Approval of reserved matters following outline consent Y/80/16/OUT for 4.5ha of residential development comprising of 3.4ha of land for the erection of 100 No. dwellings (up to 30 (30%) affordable housing) together with 1.1ha of land set aside for public open space & strategic landscaping & 2.2ha of public open space & green corridors with vehicular access from Ford Lane & pedestrian/cycle access only from North End Road. This application may affect the setting of listed buildings, affects the character & appearance of the Church Lane, Yapton Conservation Area & affects a Public Right of Way.

Land to the south of Ford Lane and east of North End Road Yapton

Thank you for your internet comments made on 12th March 2020 which has been recorded as **'support'** with the comments as follows:

Play Area (LEAP) - Scale 1:250@A1

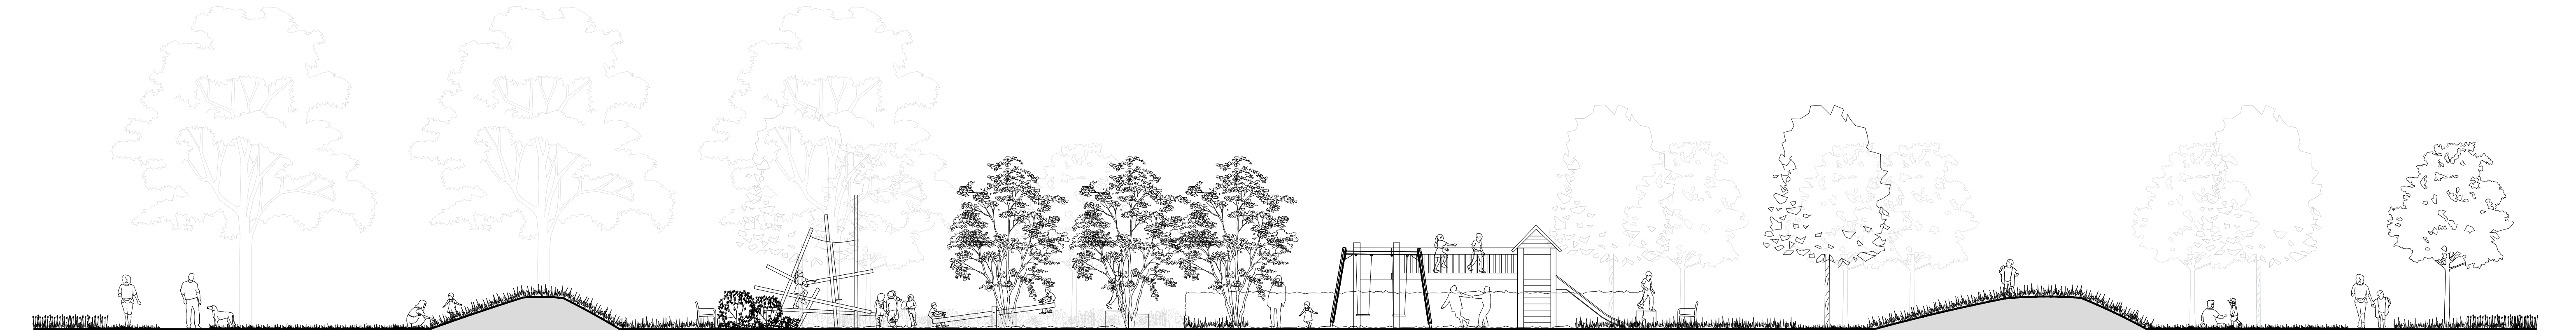
- YPC welcome the use of both LAPs and LEAPs but challenge the siting of the LEAP. The LEAP is within a few meters of the surface water collect pond which YPC view as placing small children using the LEAP at an unnecessary risk. YPC would suggest that the LEAP be relocated to more appropriate location within the scheme and the current LEAP location become a LAP. This area could then be used to encourage residents and children to explore and learn about the natural environment and wildlife of the area.
